OFFICIAL NOTIFICATION OF DECISION

Project #PR-2024-010074
Application#
VA-2024-00261 SIDEWALK WAIVER

LOT/TRACT A, COTTONWOOD zoned **NR-BP**,
located at **3601 SEVEN BAR LP RD NW** containing
approximately **1.957** acre(s). **(B-14)**

1 SITE PLAN
SCALE: 1" = 20'-0"

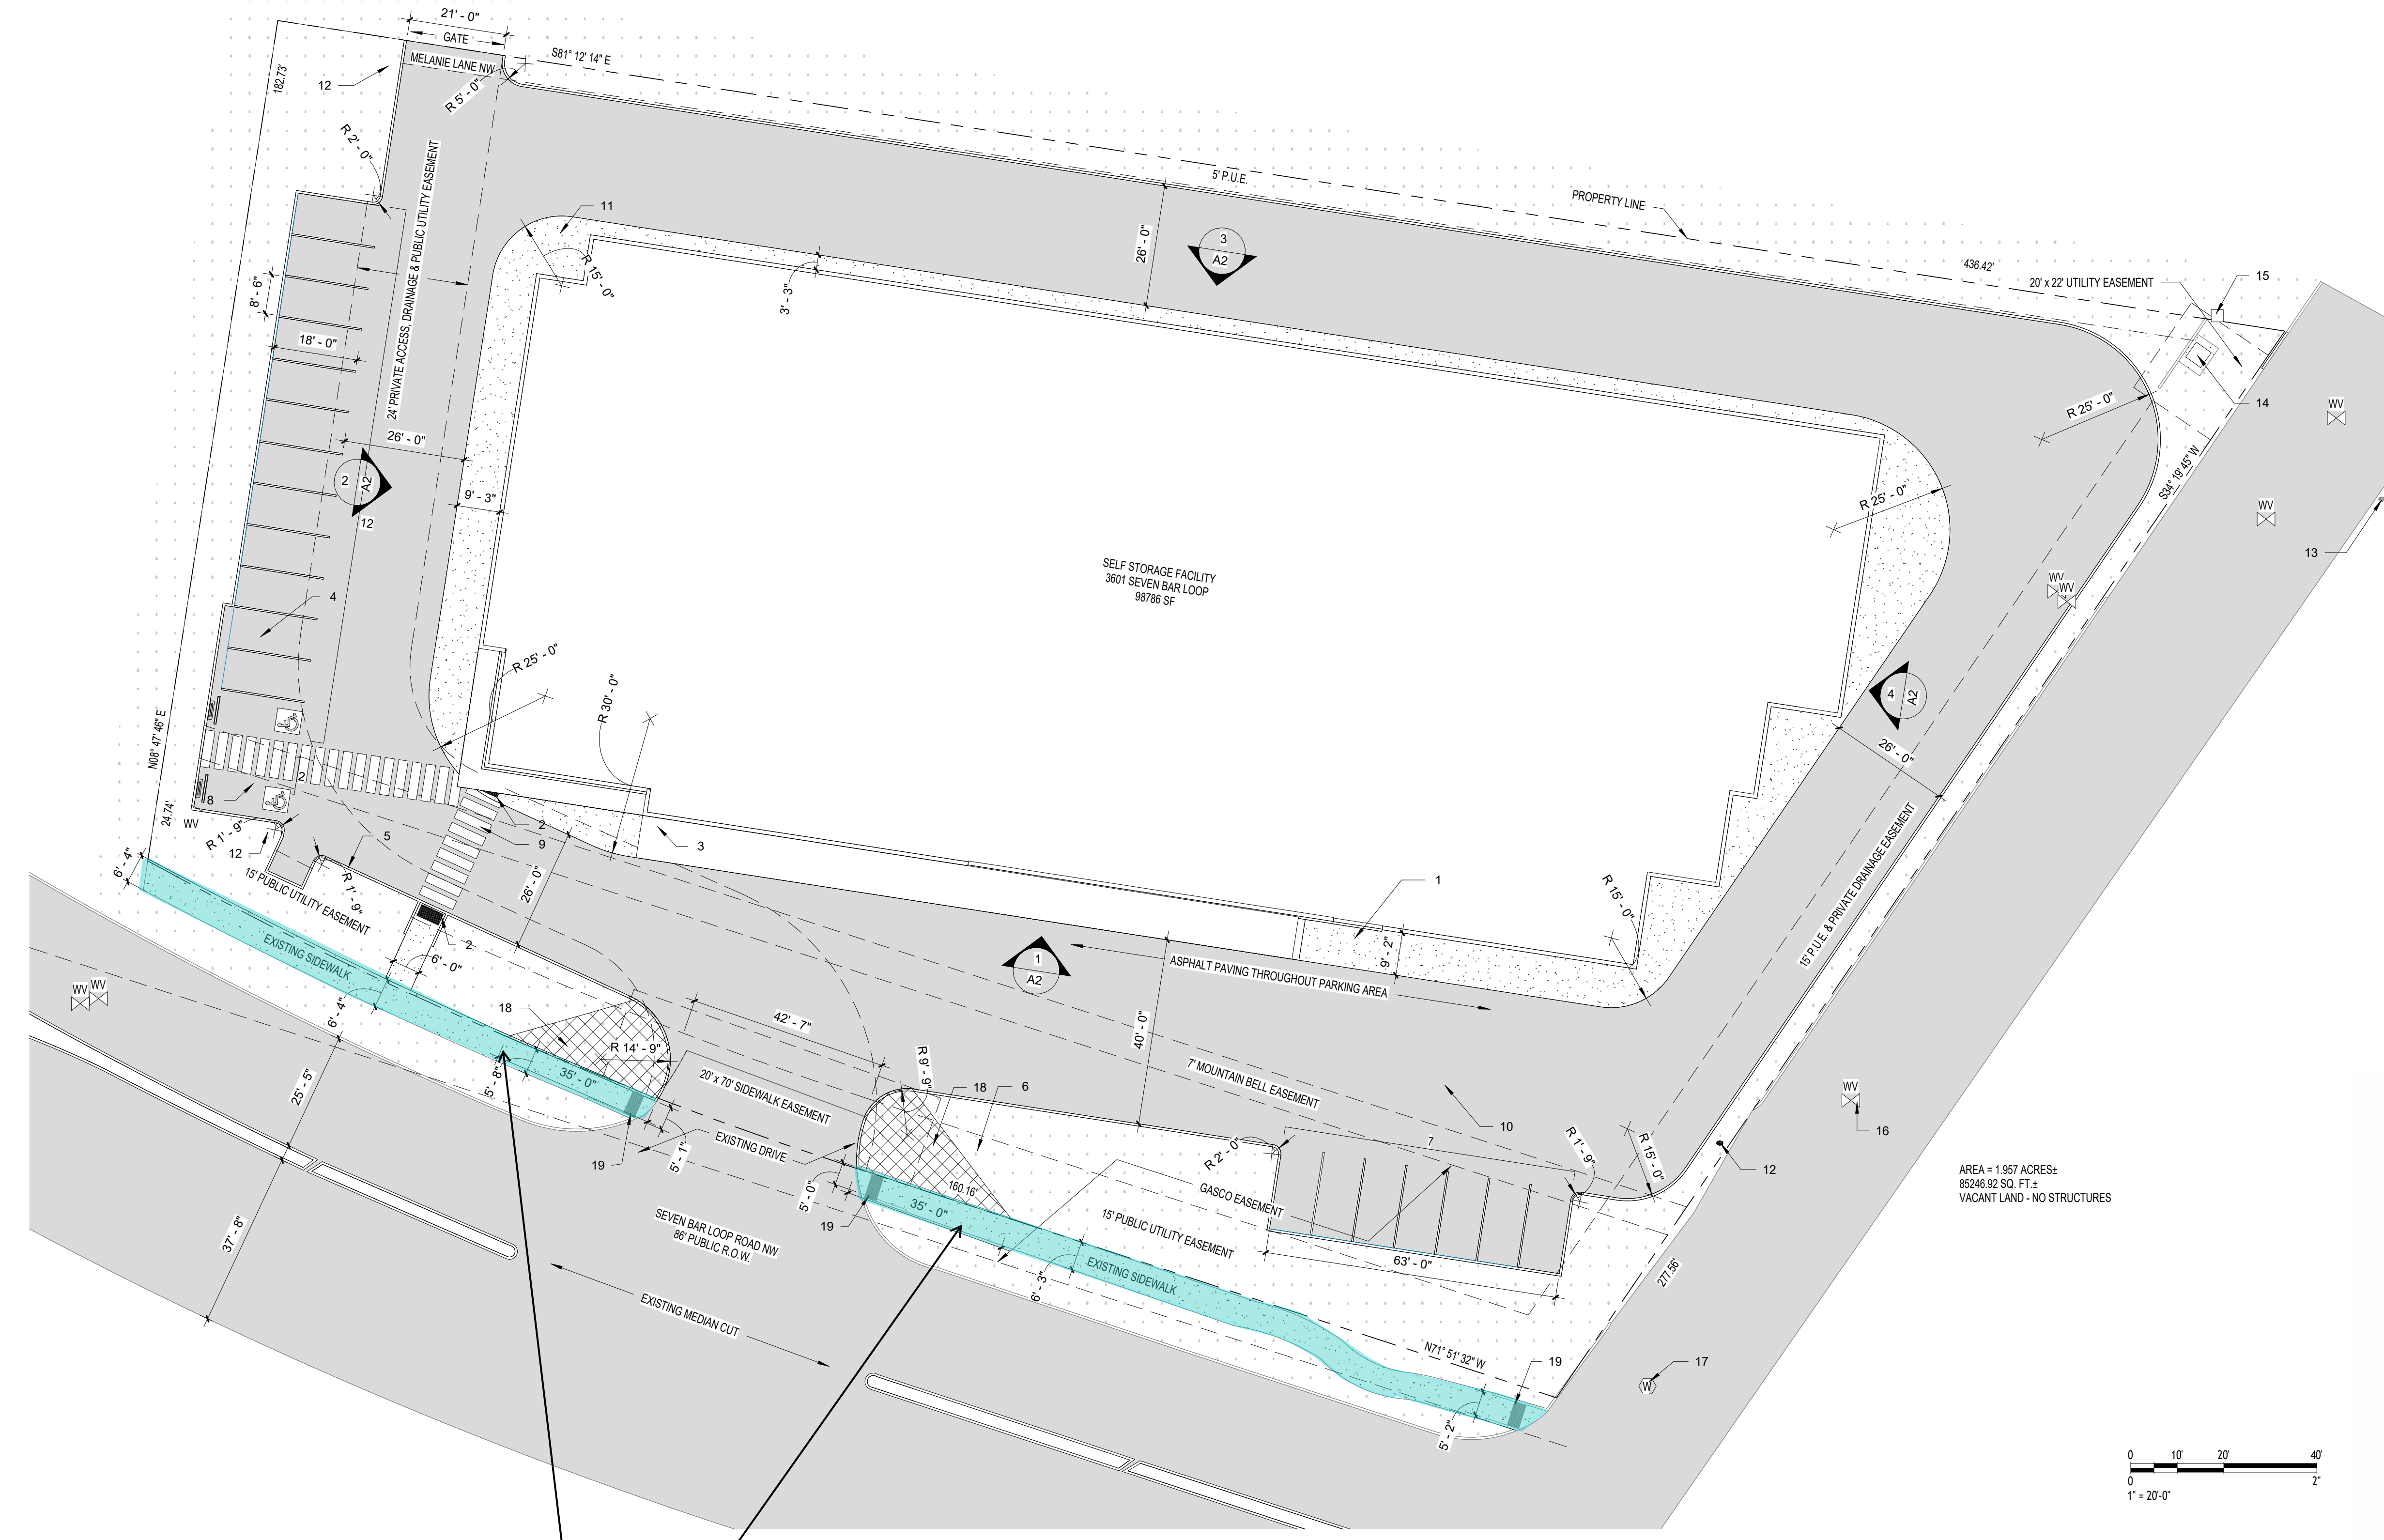
1. This is a waiver request to keep the existing sidewalks along Seven Bar Loop at their existing width of 5-feet to 6.4-feet. The DPM Table 7.2.29 requires 10-foot-wide sidewalks along Seven Bar Loop at this location because it is an Activity Center.
2. Transportation Engineers reviewed the waiver request and did not find the Applicant made sufficient justification to waive the required wider sidewalk. The existing sidewalk could remain with an additional widening of 3-5 feet.
3. The DHO made no findings or conclusion regarding IDO 6-6(P)(3)(b)(2) because the threshold question of no significant public purpose was not satisfied and, therefore, findings for these criteria were not necessary.
